Planning Application Reference No.: 3/2026/0354

Address of Development: 13 Brookside
Old Langho
BB6 8AP

Comments: Subject: Objections to Proposed Extension

Notes
This drawing is the property of IDC Home Architecture Ltd and copyright is reserved by them. This drawing is not to be copied or disclosed by or to any unauthorised persons without the prior written consent of IDC Home Architecture Ltd.

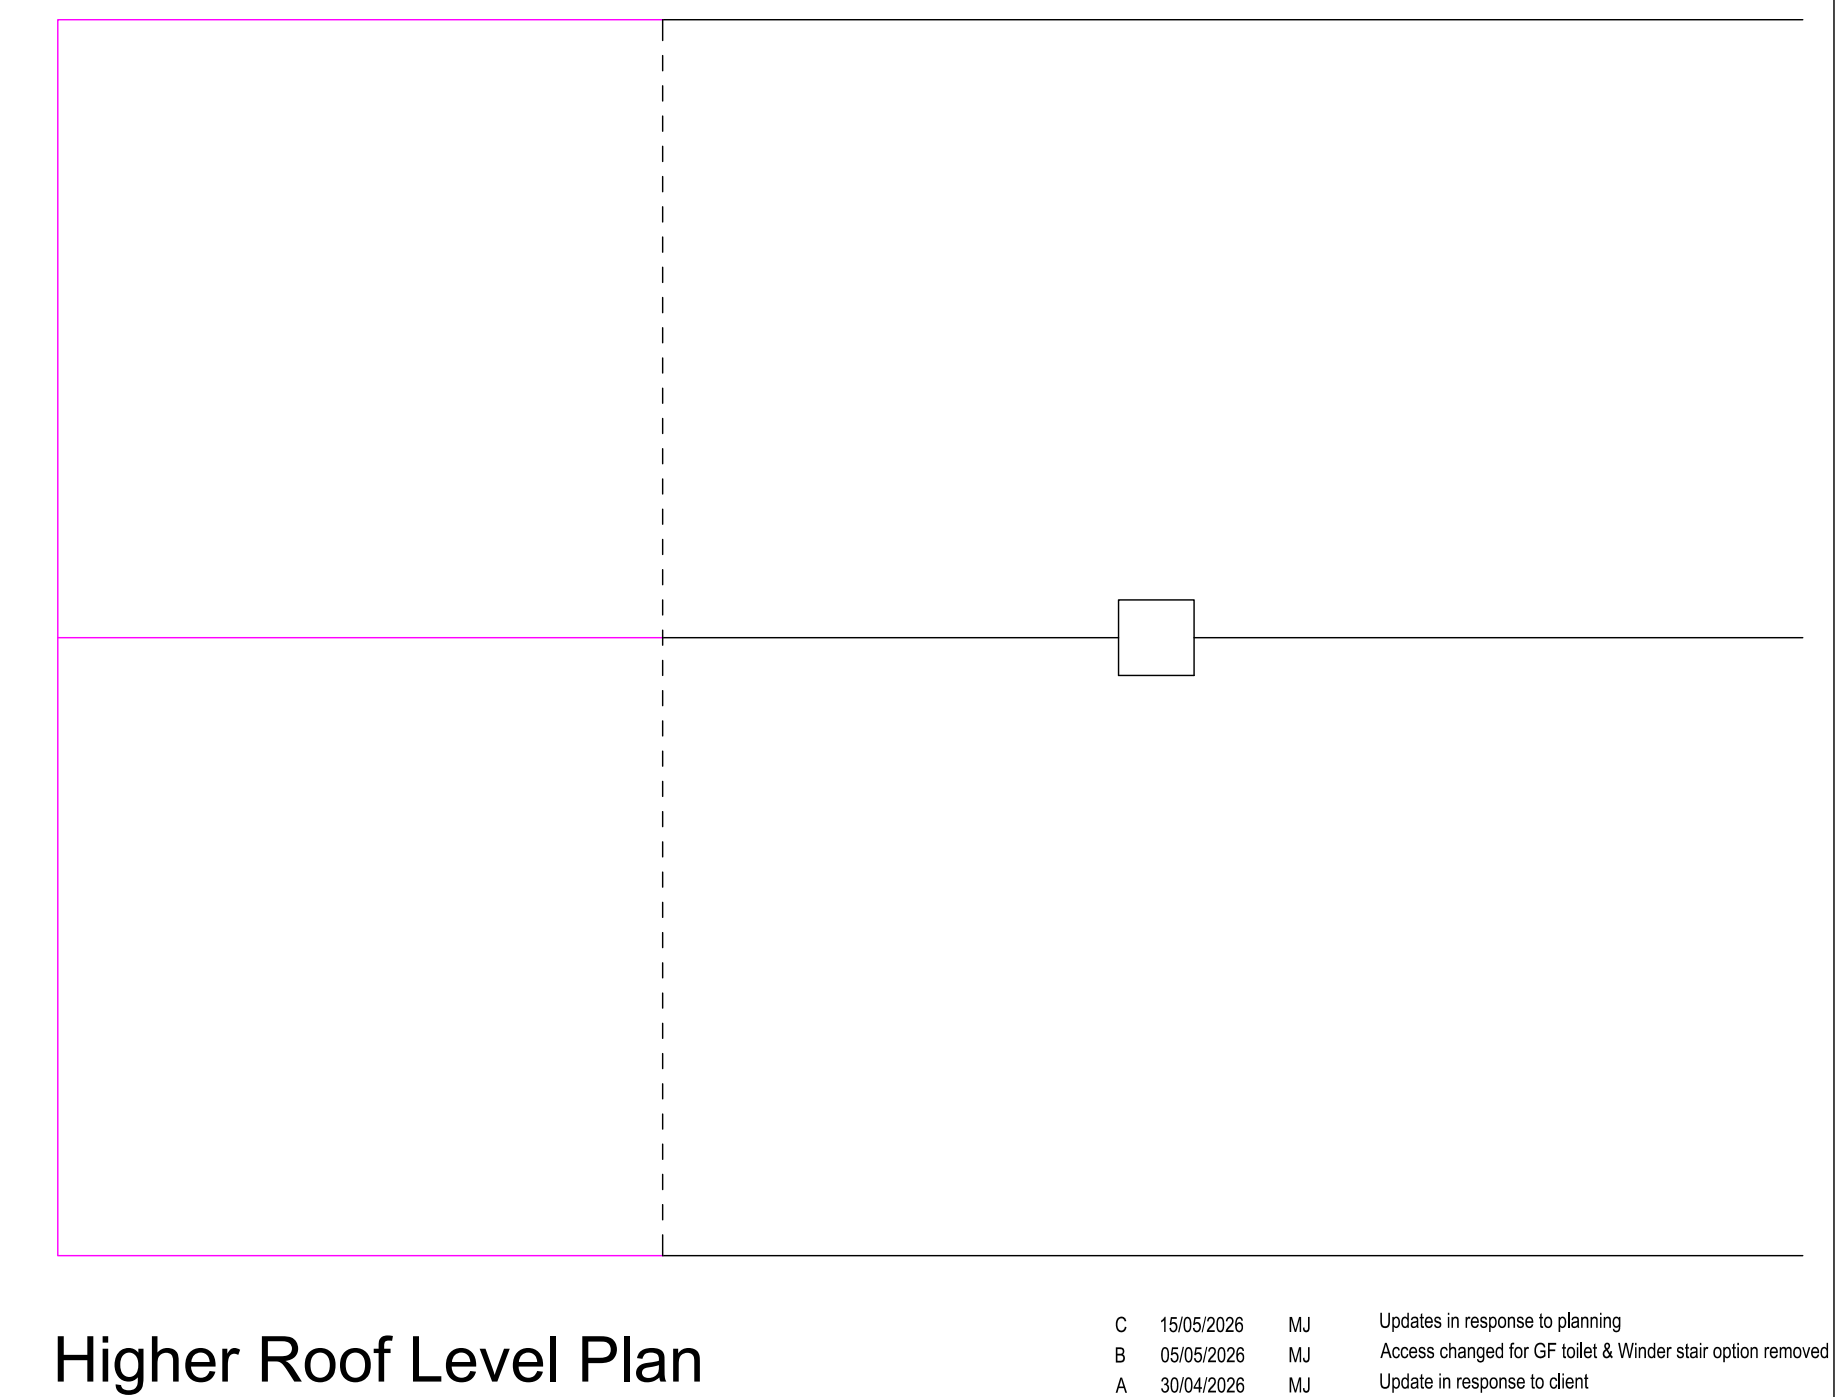
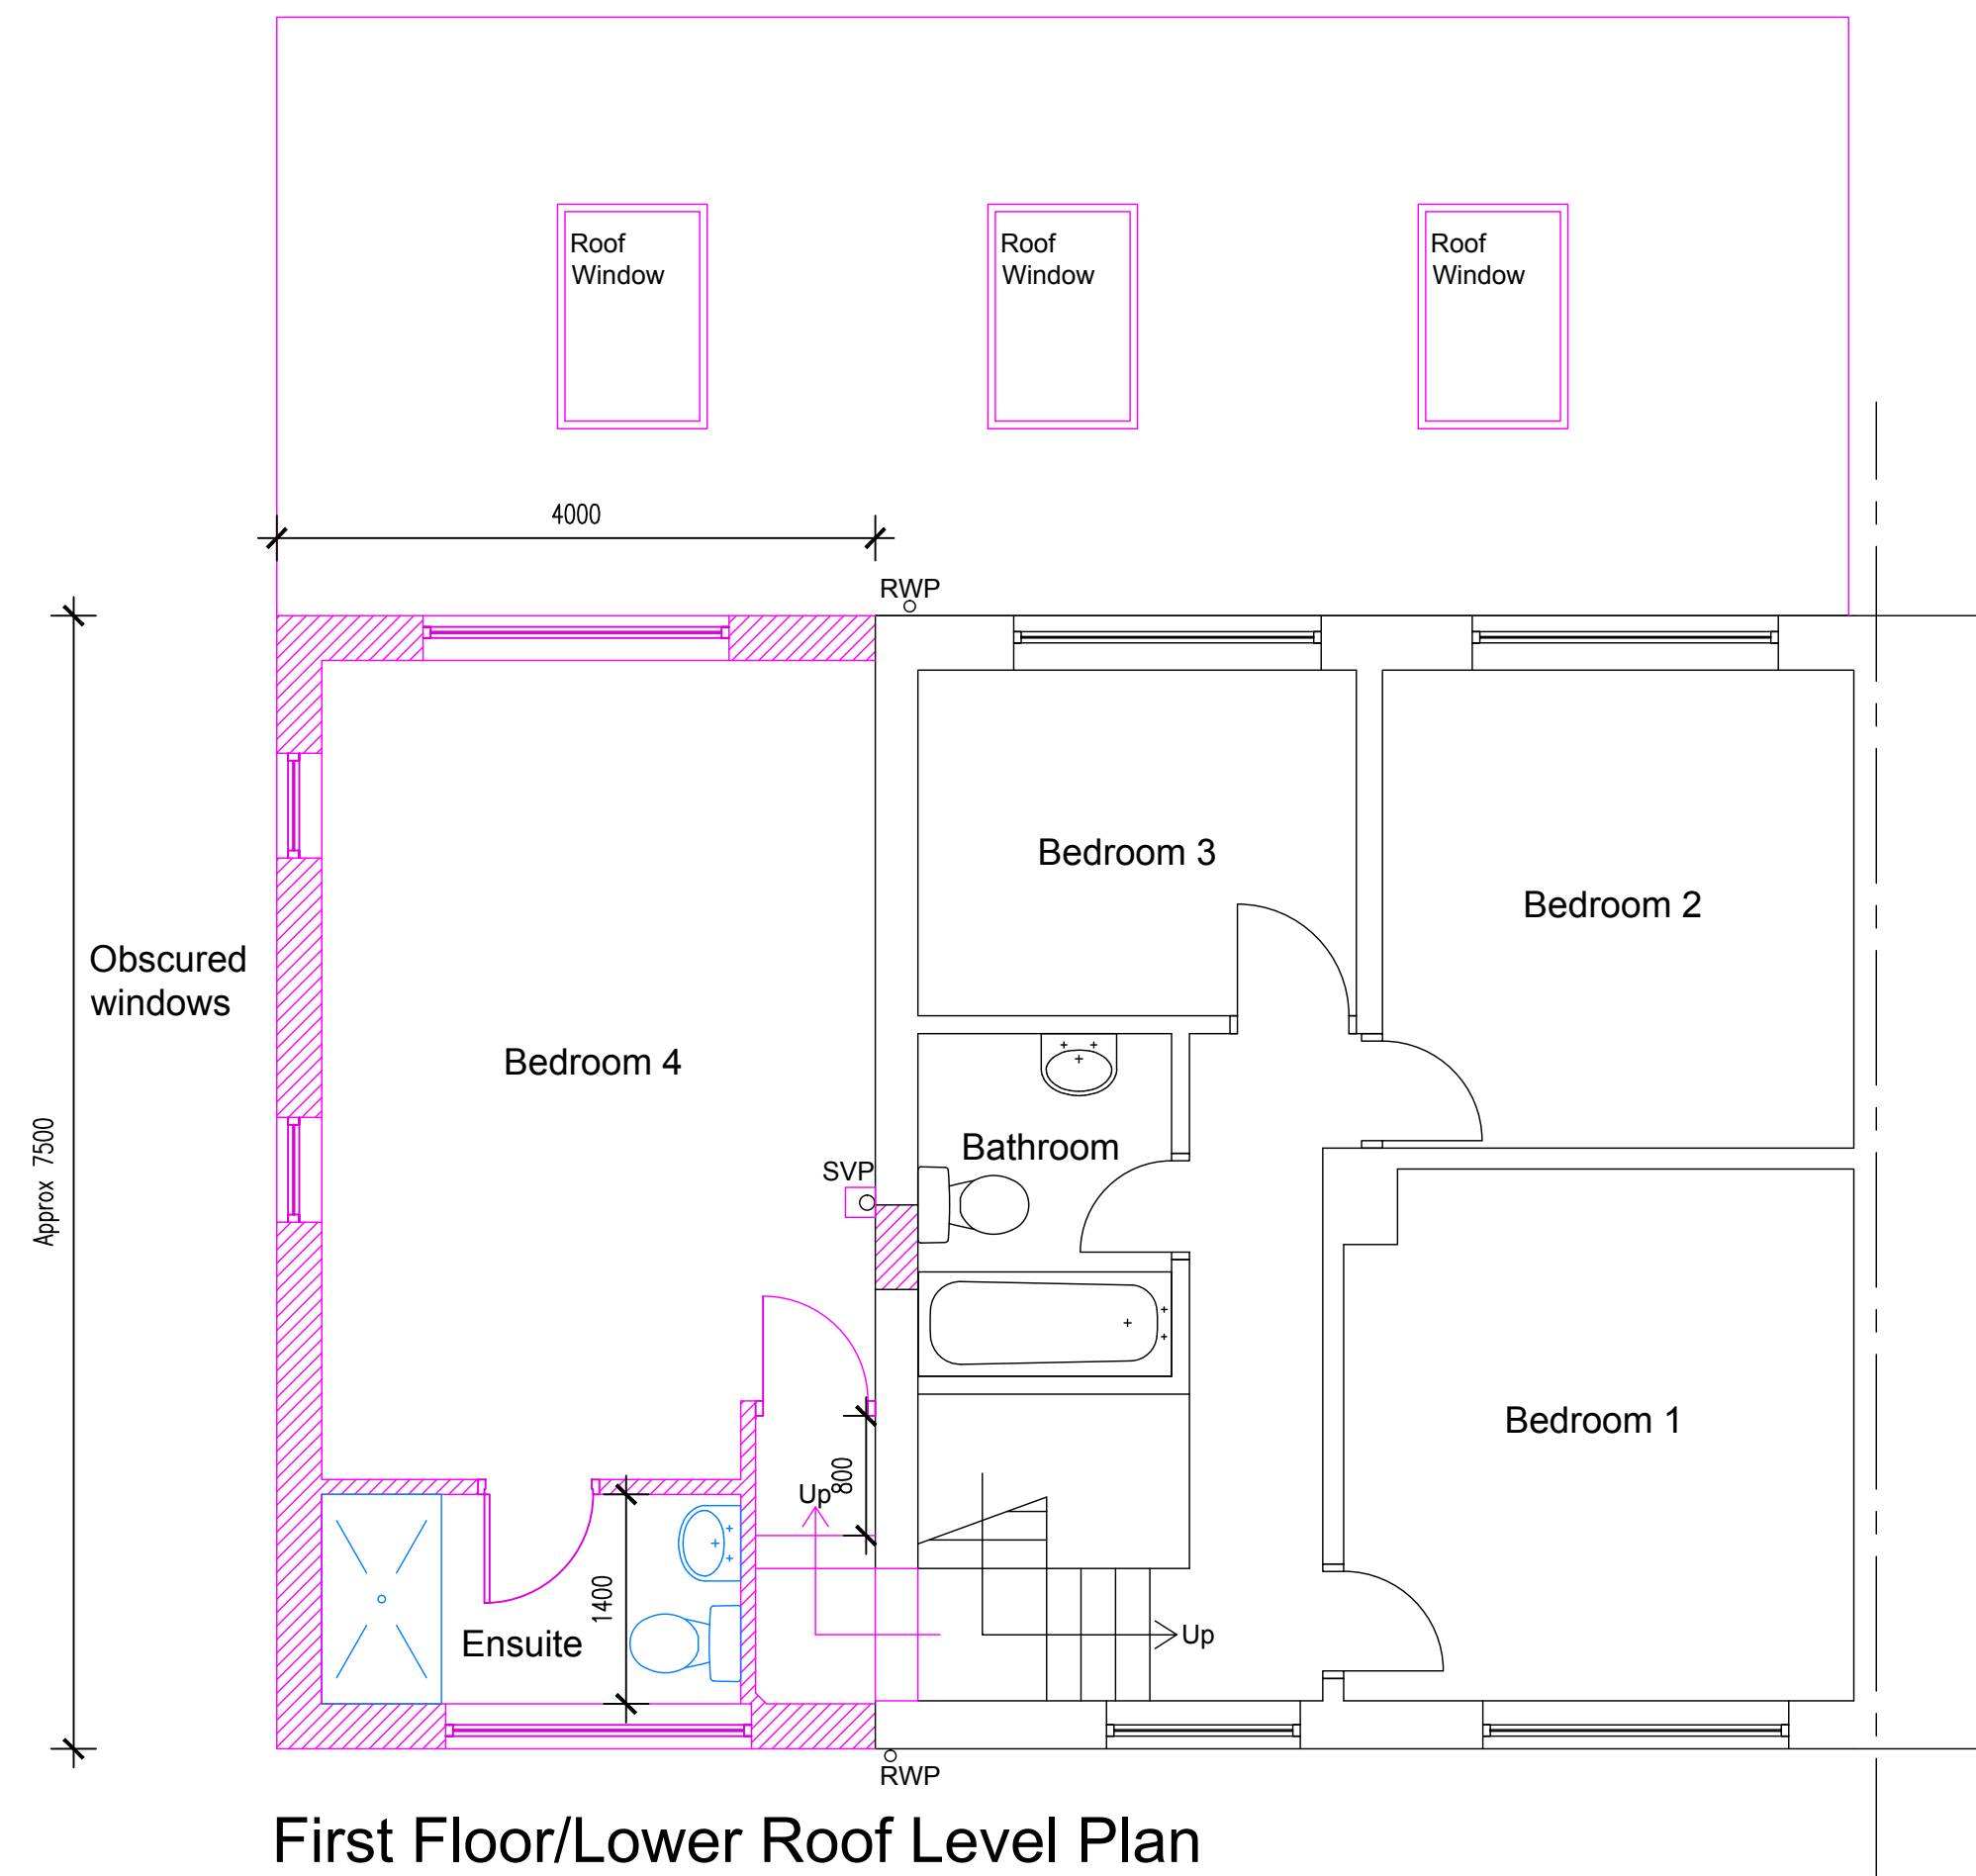
While I appreciate that homeowners are entitled to improve their property, I have concerns regarding both the scale of the proposed development and the impact it will have on neighbouring homes. I am particularly concerned about the proposed first-floor front en-suite window, which would [REDACTED] Given the relatively narrow distance between the houses, this window would result in a significant loss of privacy and allow [REDACTED] The sheer size of a clear glass window as a en-suite in this location would cause a direct and highly intrusive invasion of privacy into [REDACTED] I believe this would be contrary to Ribble Valley Core Strategy Policy DMG1, which seeks to protect the residential amenity of existing neighbouring properties.

As this window serves a non-habitable bathroom rather than a primary living space or bedroom, I do not believe clear glazing is necessary. I therefore respectfully request that, should planning permission be granted, the Local Planning Authority imposes a condition requiring the en-suite window to be in keeping with a normal size bathroom window and fitted with obscure glazing (minimum Pilkington Privacy Level 3 or 4) and to be non-opening below 1.7 metres above the internal floor level, in order to protect the privacy of neighbouring residents.

I have also concerned that the overall size and scale of the extension is excessive for the plot and will have a detrimental impact on the character of the surrounding area. This development appears much larger than neighbouring properties and risks being overbearing.
